Subject: RE: Y/10/22/PL Land to the south of Ford Lane and East of North End Road

I have however assessed the plans and noted the following 'issues':

Play Area (LAP 2) - Scale 1:100@A1

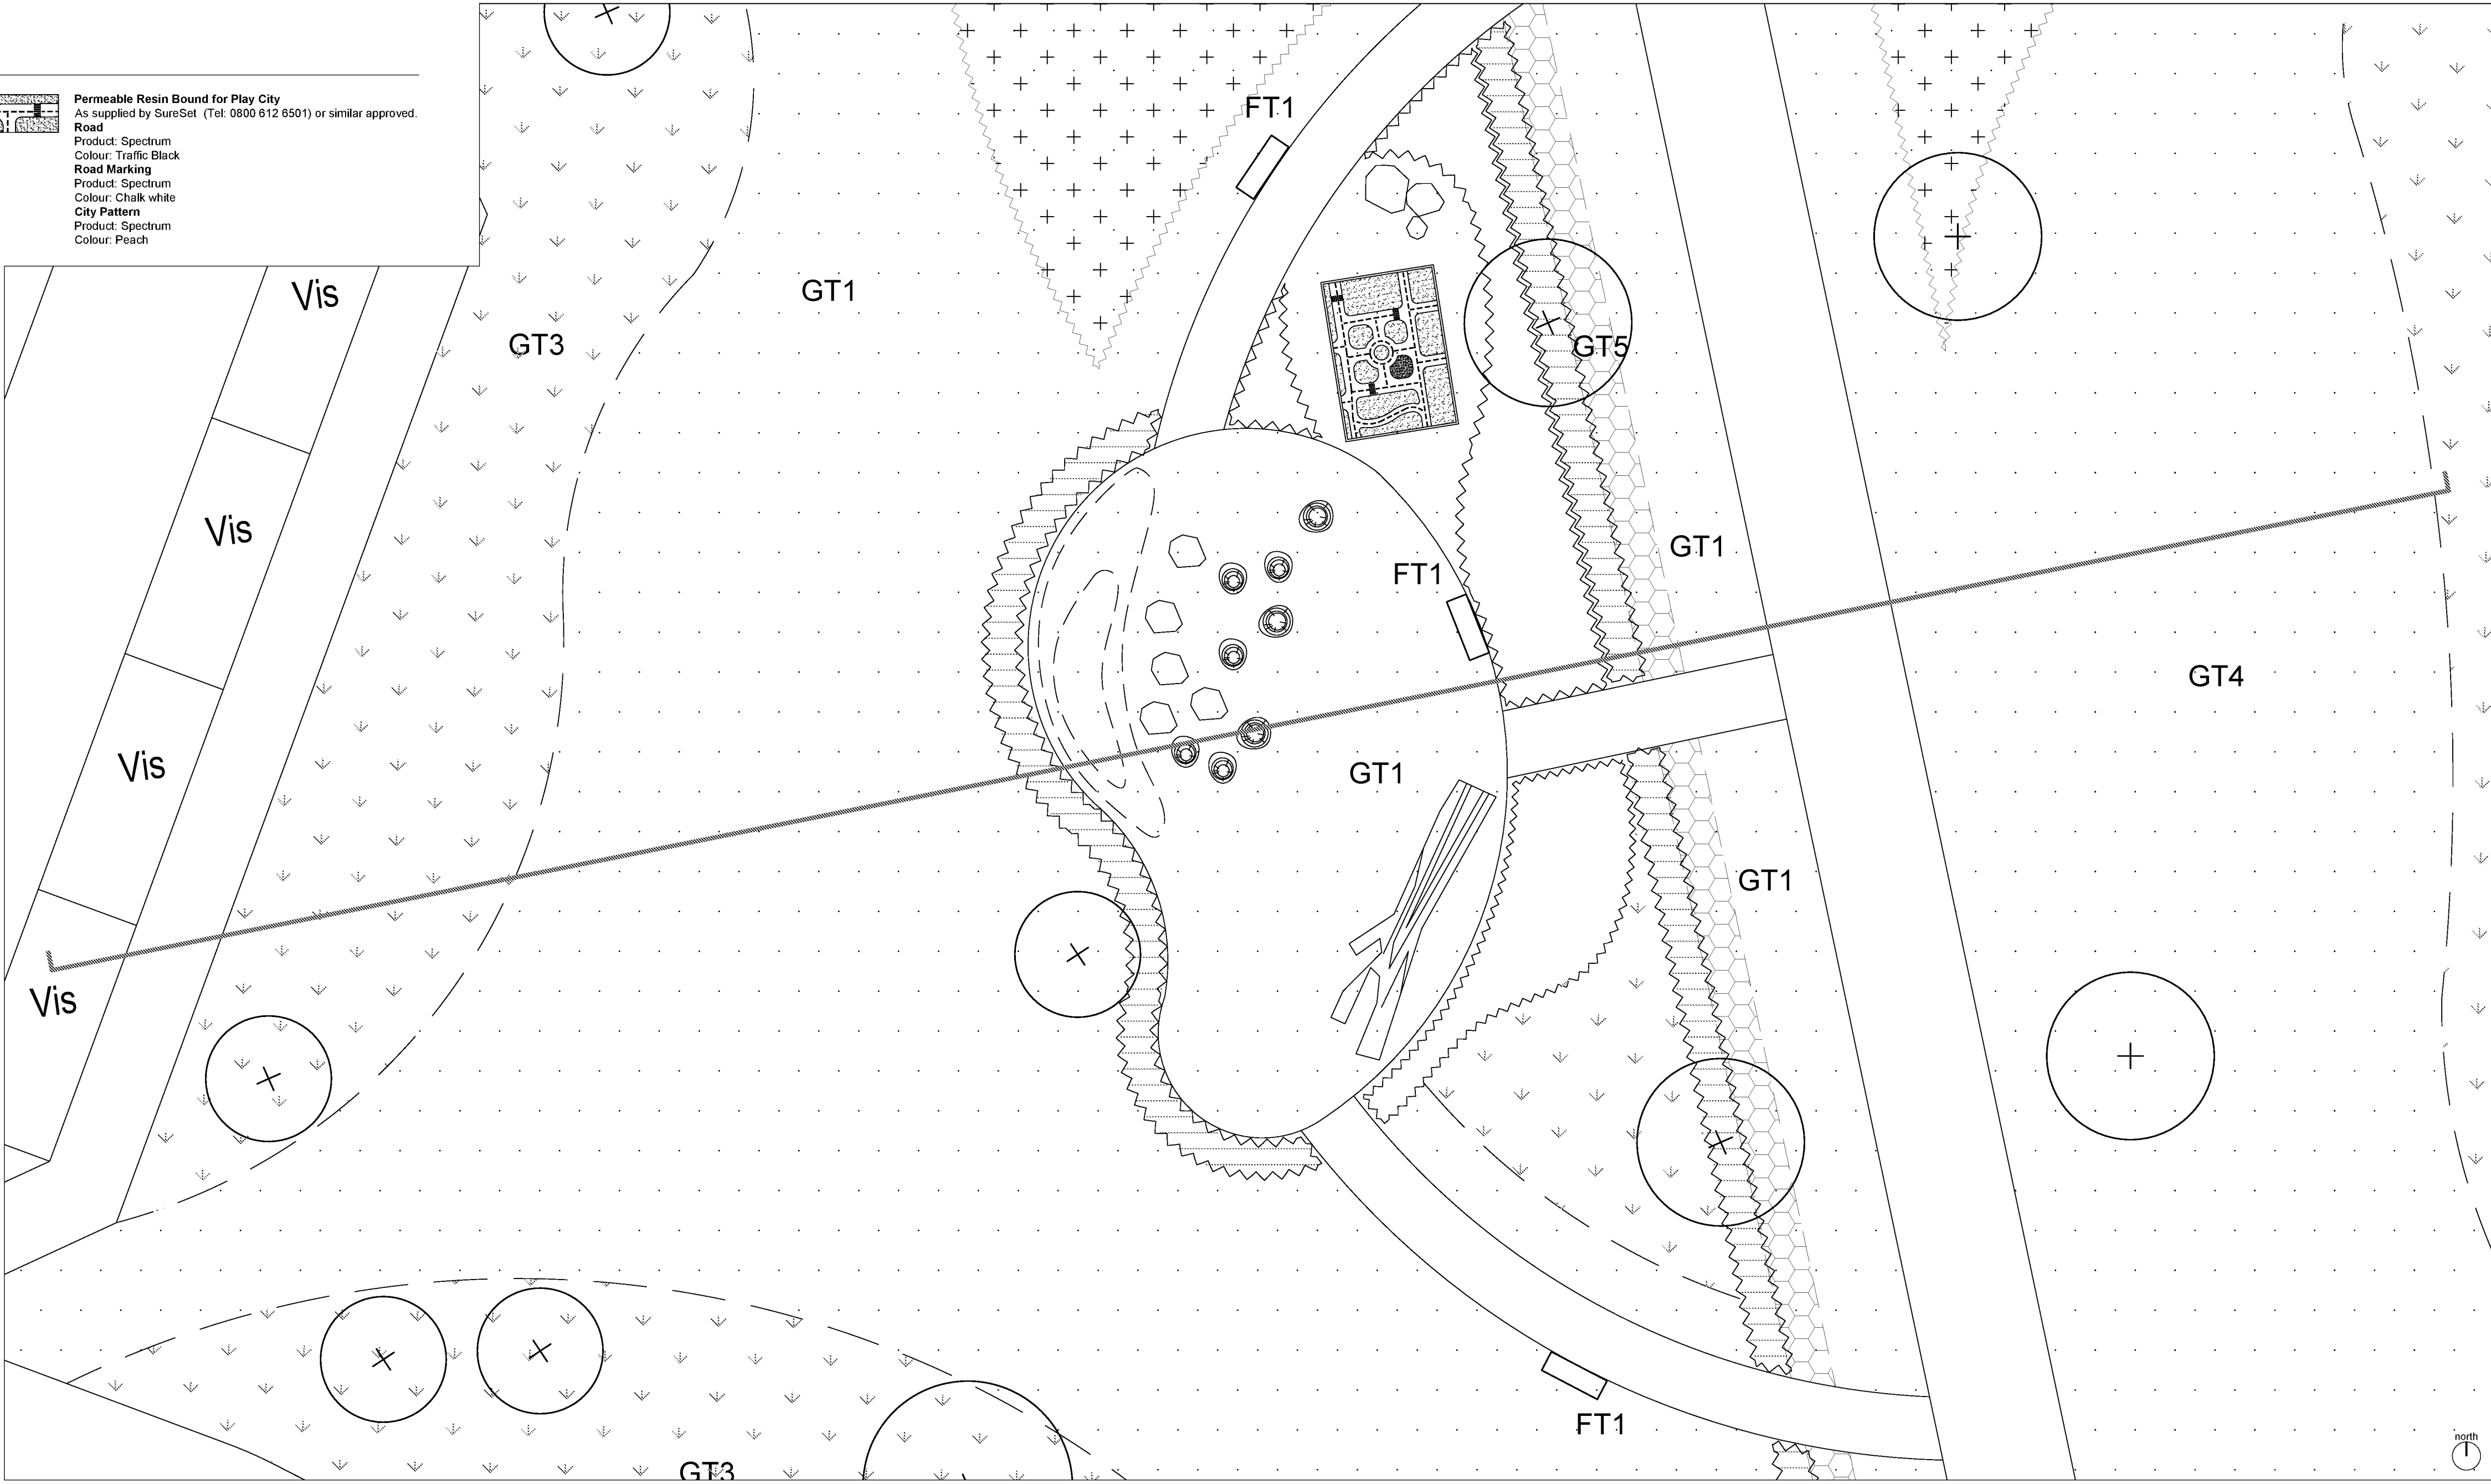
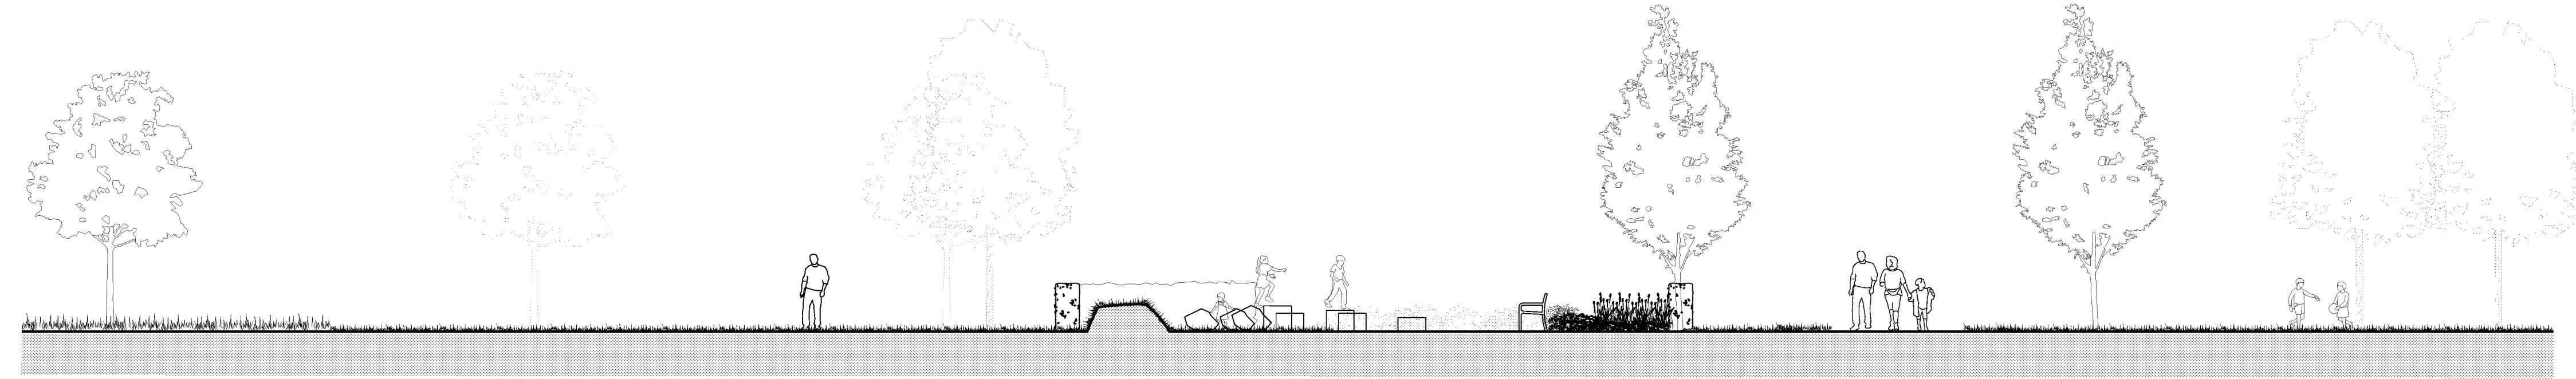
- How is the play area to be secured from the adjacent SuDS to prevent kids running off into water? There does not seem to be any barrier between the two.

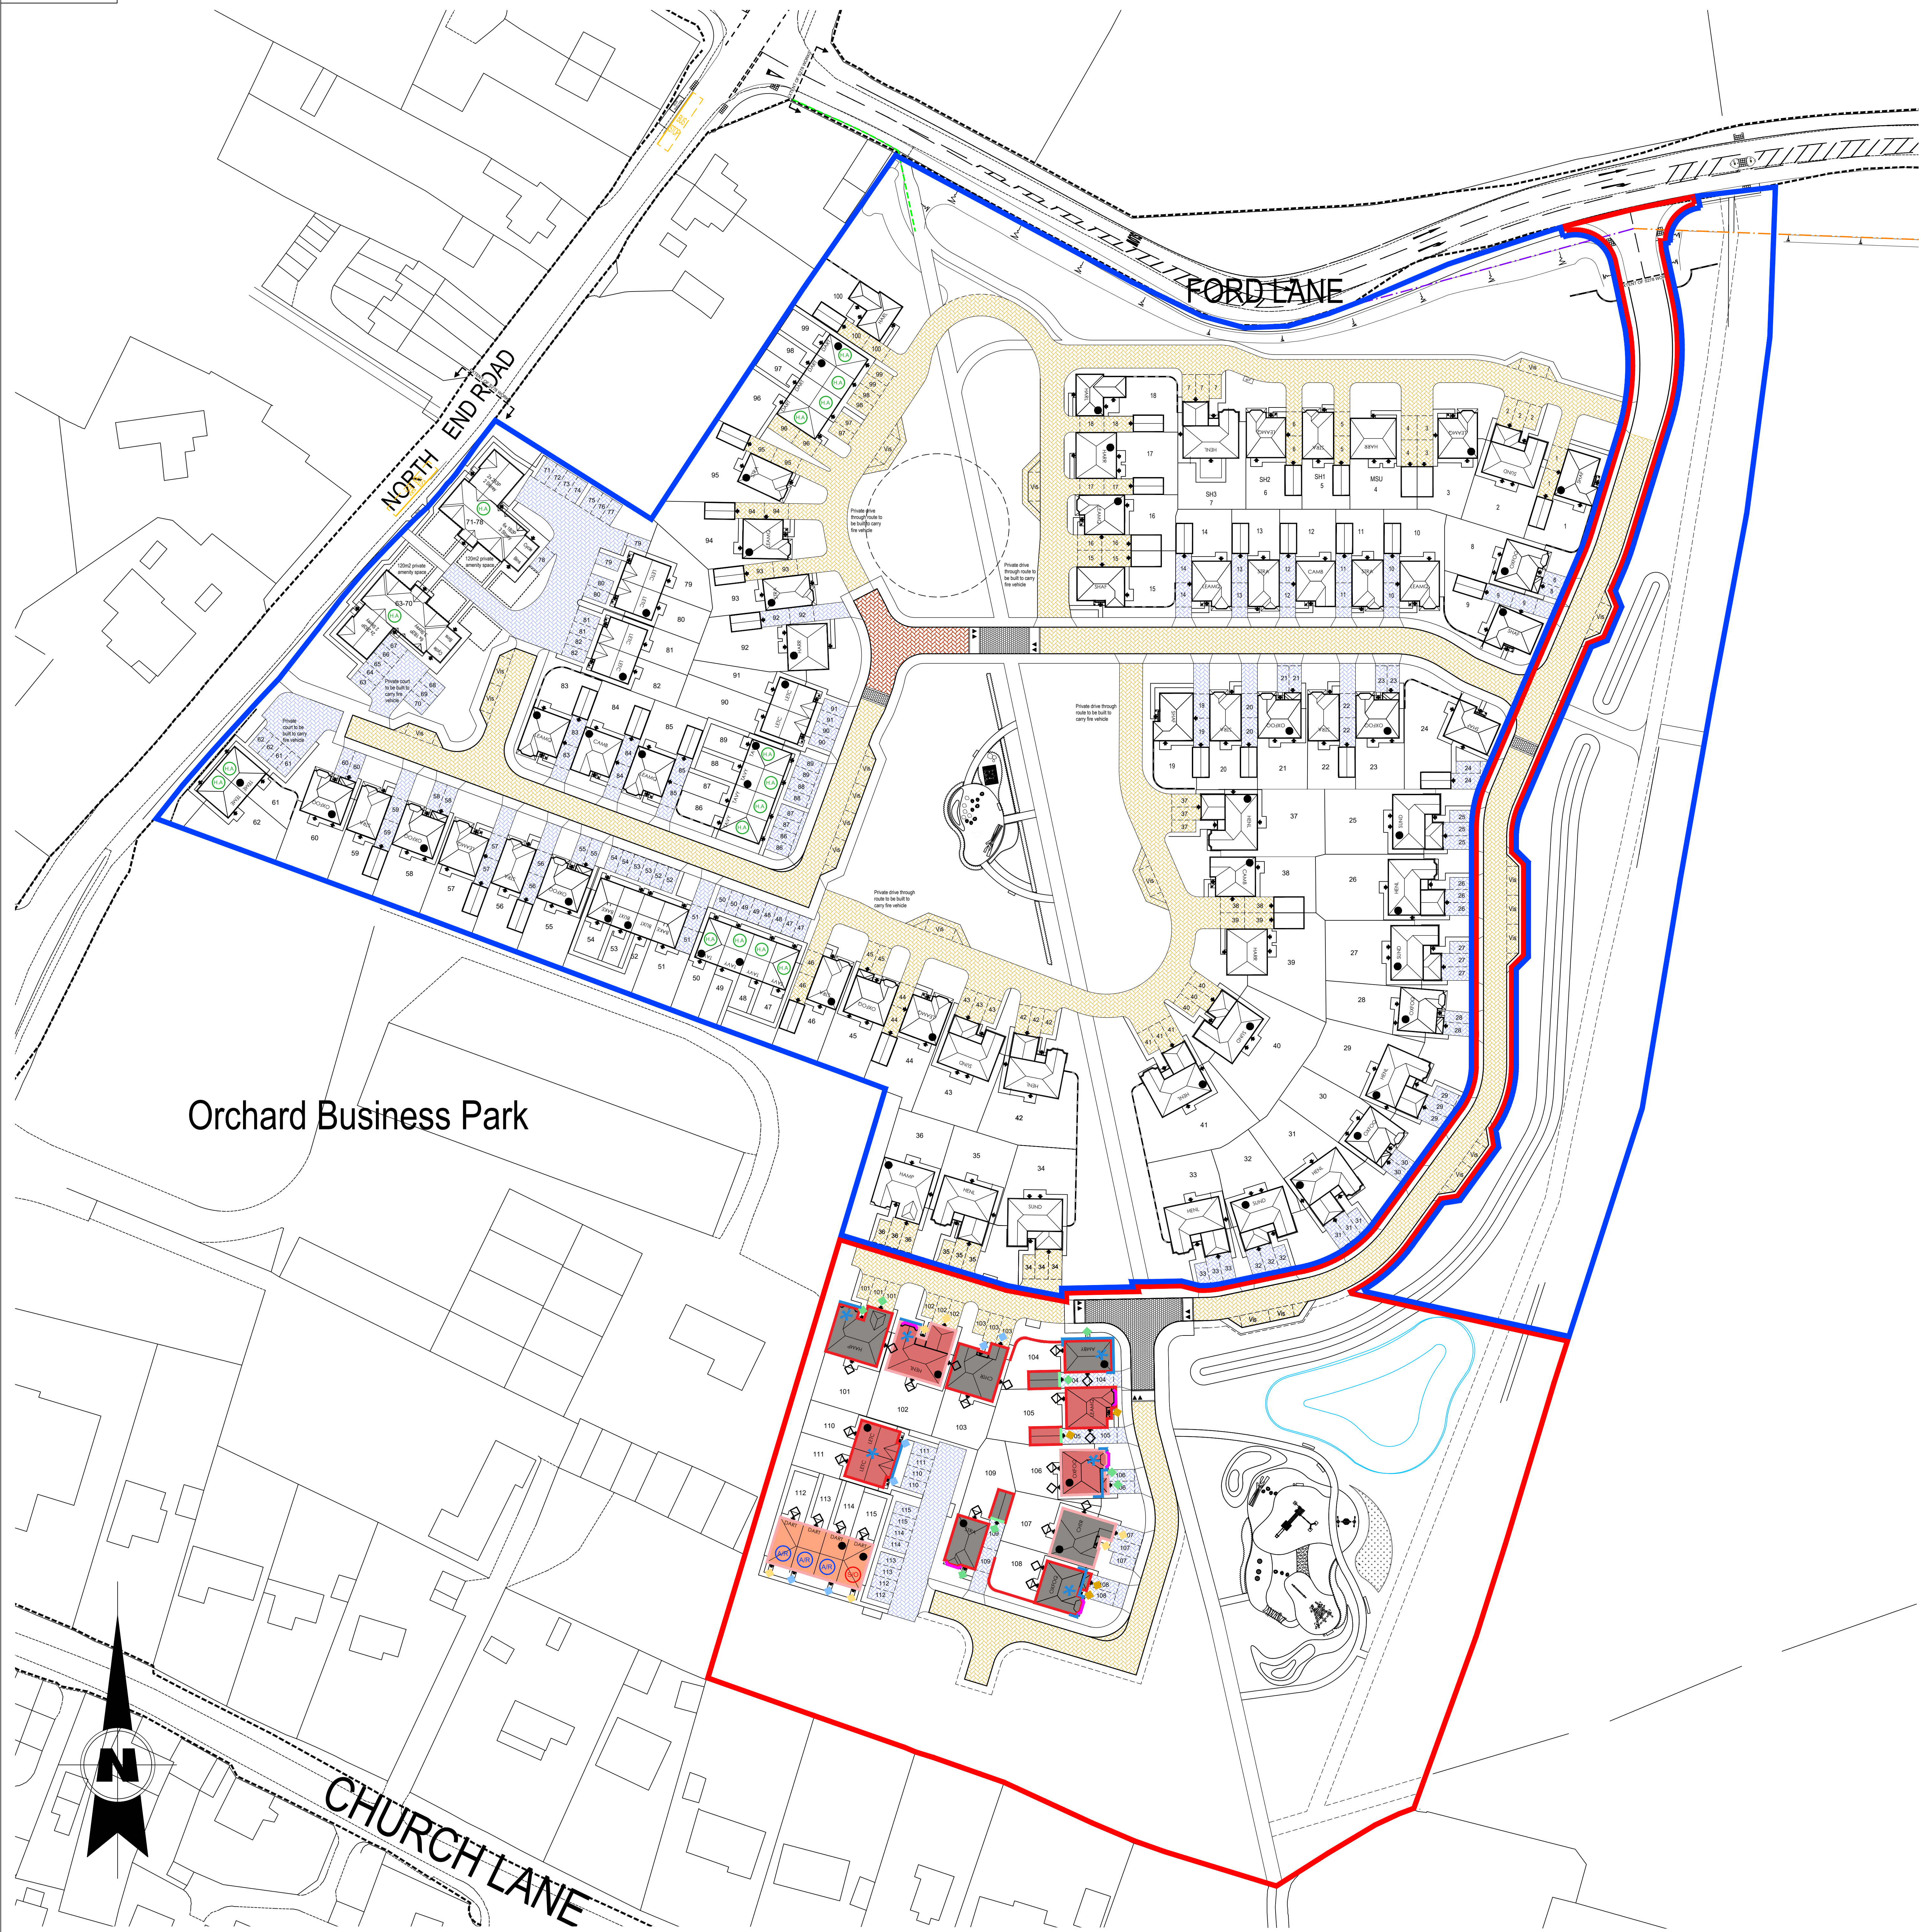
- There are some minor garden shortfalls in depth versus the Arun Design Guide (ADG) standards in that plot 112 & 115 are both 10m deep. However, as the shortfall is only 0.5m, this is not a serious concern.

- There are shortfalls in the interface distances as per the ADG between 114's rear and 111's side (12m vs 14m) and between 102's rear and 110's side (12m vs 14m). Whilst the ADG is only guidance, I will have to report this and our members (should this be a Ctte item) are very keen to see the ADG standards observed.

- The Affordable Housing is clustered as one terrace which is in conflict with ALP Policy AH SP2. As all AH units are one house type, they will also not be tenure blind. The AH homes should at least be spread out a little such as by swapping some of the terraced units with plots 104, 109, 110, 111 thus ending up with say half of the terraced units as market & half as AH. I have no objection if there is then a 50% split down the middle of the terrace.

- The layout needs more street trees to break up the parking run outside plots 110-115. I note that ground level vegetation is proposed but we would want to see street trees also, provided that they have room to grow.

- The western buffer seems to measure at 4m wide not 5m as stated in the documents.
- Plot 101 is side on to the immediate rear garden of the adjacent Orchard Barn. I note that there is an en-suite window proposed in the elevation facing the neighbouring garden and that this could be obscure glazed. However, our preference is no window in this elevation because it will introduce perceived overlooking and harm the neighbours amenity.

- The visitor parking provision is under (2 vs 3) but the overall parking provision is over the requirements (40.5 vs 38 required) so not an issue. However, please note that our Parking Standards SPD refers to the need to ensure 5% disabled parking provision as per Manual for Streets (MfS). I can't see any reference to this in the submission and this needs to be shown.
